# Comments for Planning Application 21/02839/PLF

Application Number: 21/02839/PLF

Address: Manor Farm Low Field Lane Haisthorpe East Riding Of Yorkshire YO25 4NX

Proposal: Erection of a lean-to extension to be used for agricultural machinery storage and repair

Figure 20 Map of the site and immediate surrounds, showing impermeable surfaces and outline drainage system

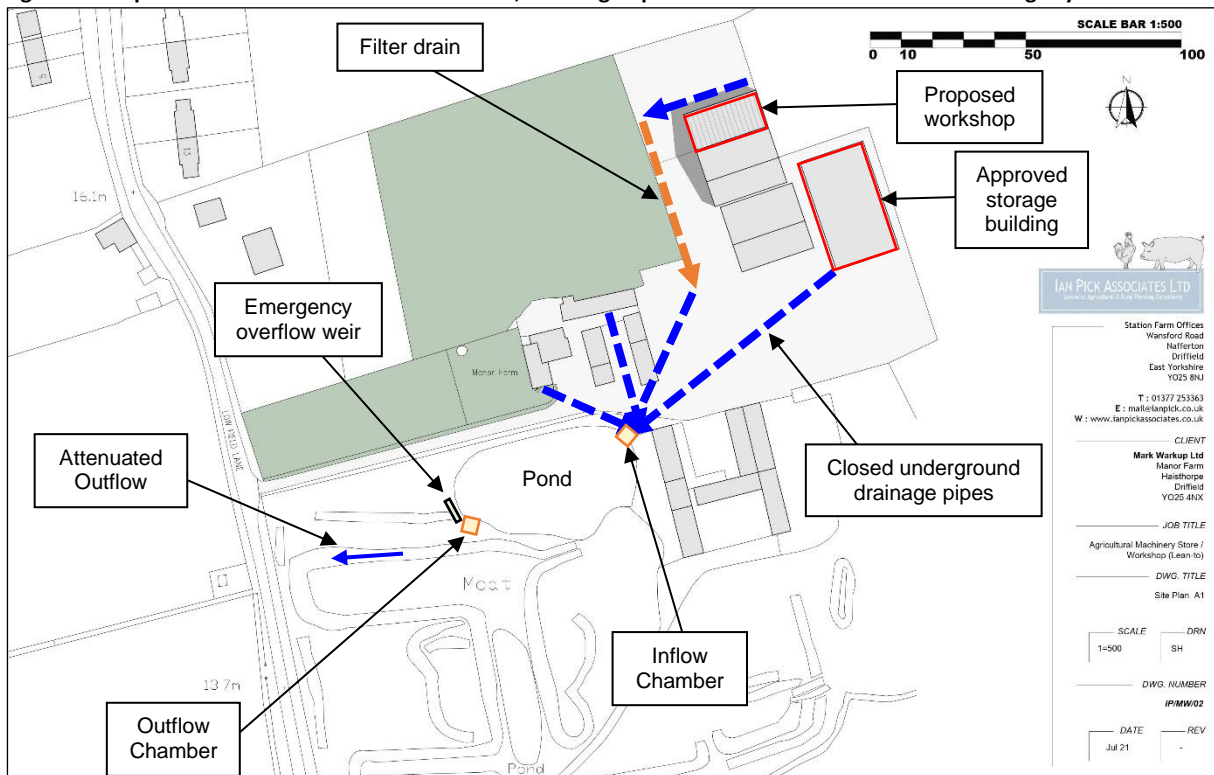
- Please see figure 20 of the '#Flood Assessment Risk' - the proposed water flow is incorrect
- Please see figure 21 - 'Attenuated Pond Design' This photo does in no way capture the pond at its resting height. At present the pond level can be adjusted to suit the time of the year and is kept high in spring to allow for summer evaporation. This photo was obviously taken during summer as the pond normally never goes this low in autumn or winter. In autumn and winter the depth is much greater than illustrated. Also, the outlet is currently positioned around 4 inches below maximum level, not the stated 18 inch - which does suggest a much higher capacity that is achievable.
